Online Comment

Application H11-0128-23
Location Land to Rear of 45-47 Bridge Road Long Sutton Spalding PE12 9EF
Proposal Demolition of existing commercial buildings and erection of new office, admin buildings and workshops (B2) to accommodate the relocation of Tears Recovery

Name Ollie Abrams
Address Environmental Protection Officer SHDC

Date Submitted 21-02-24
For/Against Comments

D	13/03/23	FLOOR LEVEL IN OFFICE RAISED FOR FRA
C	17/01/23	DETAILS AMENDED
B	31/10/22	DETAILS AMENDED
A	07/01/22	DETAILS AMENDED
Rev	Date	Detail

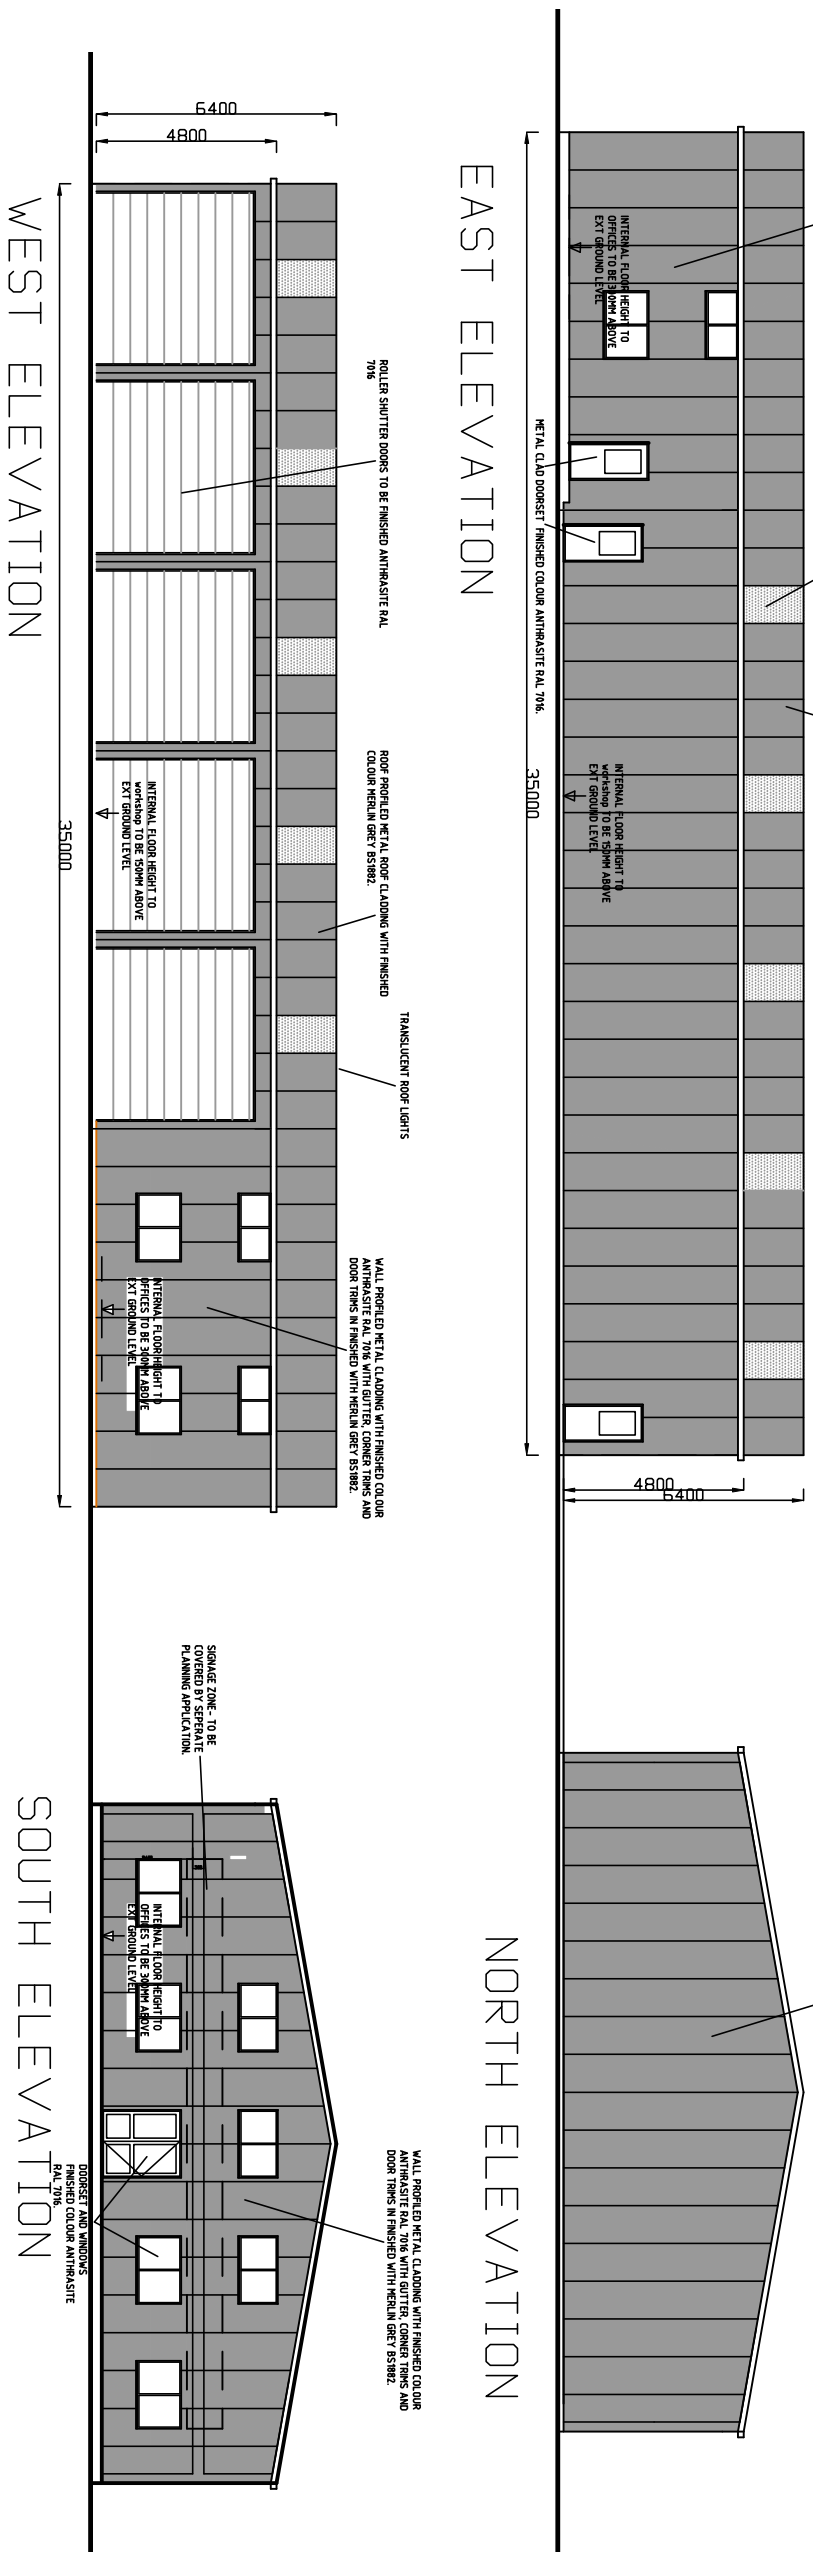
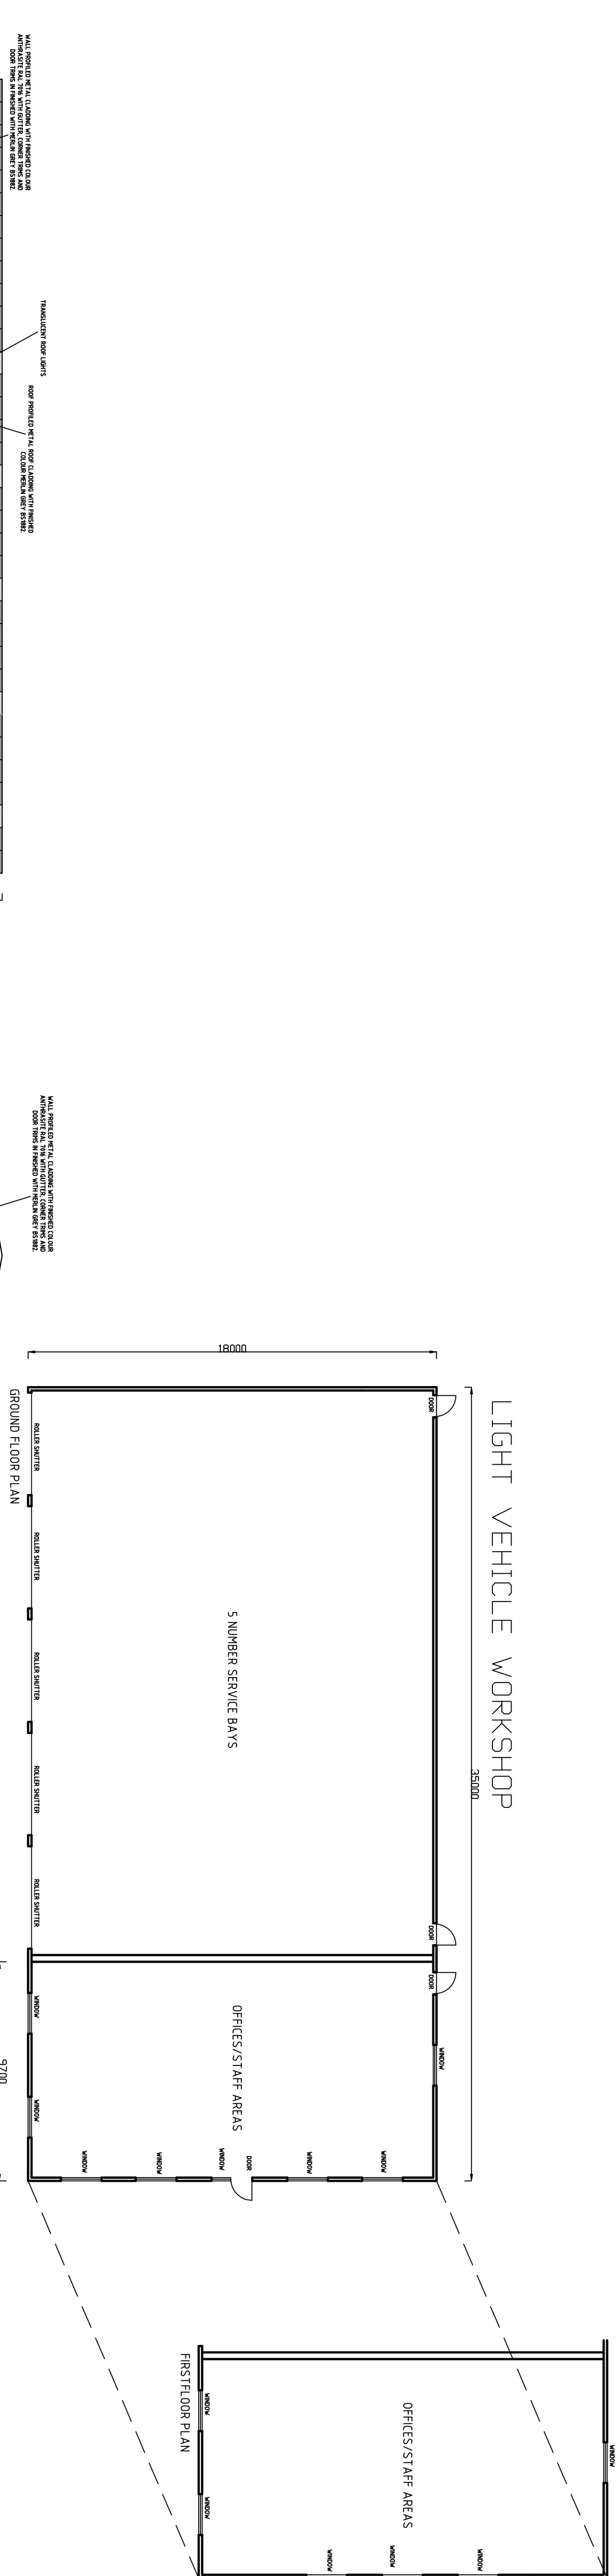
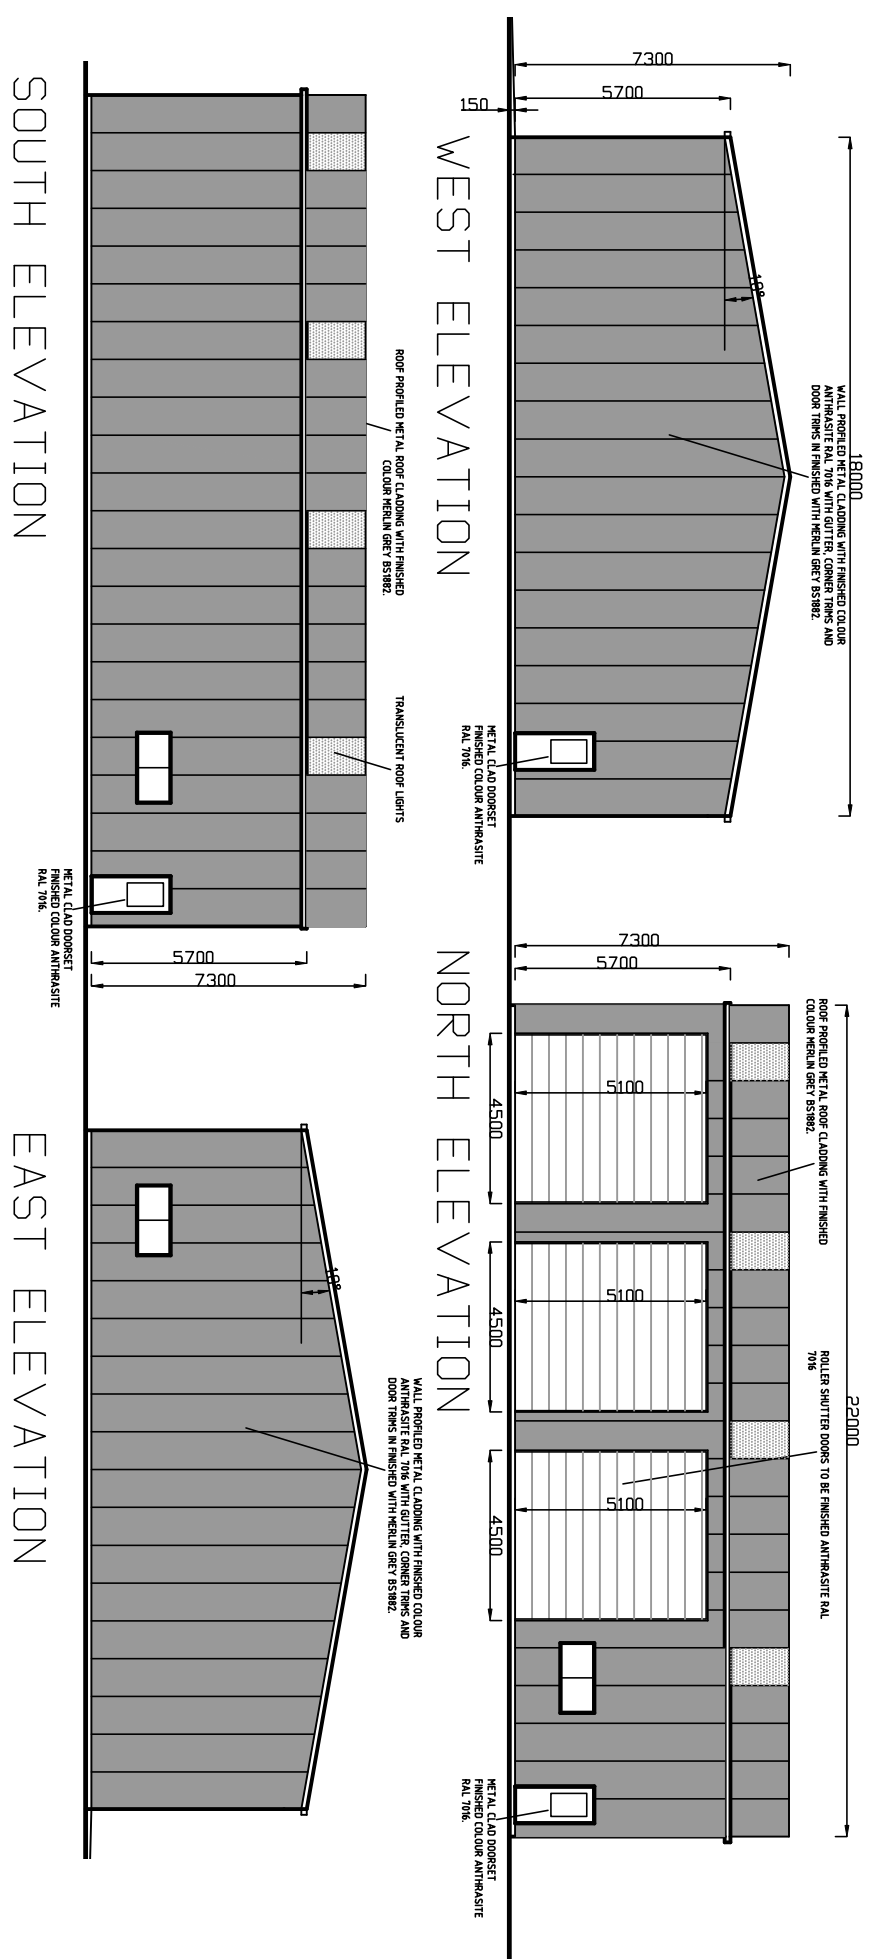
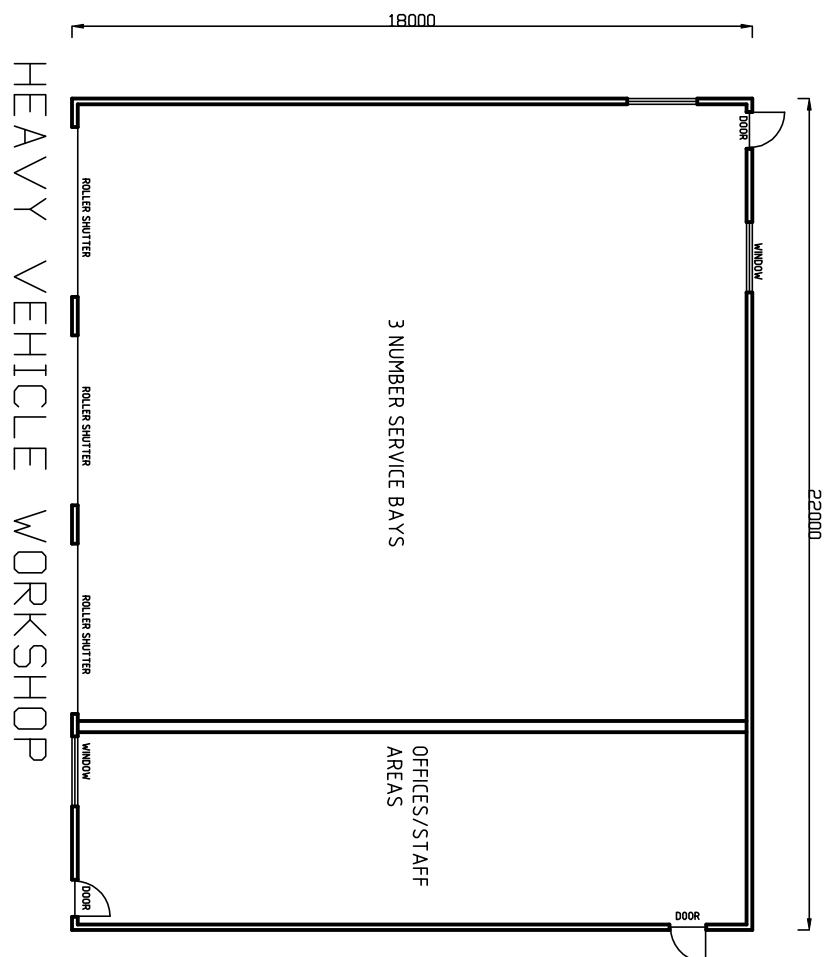
However, I note that the proposed 2.1 metres fencing proposed at the rear and side of the closest residential dwelling maybe insufficient for preventing impact of noise on the first floor of this dwelling. Therefore, I request a condition is applied for added noise insulation along these boundary's closet to this dwelling to protect the local amenity.
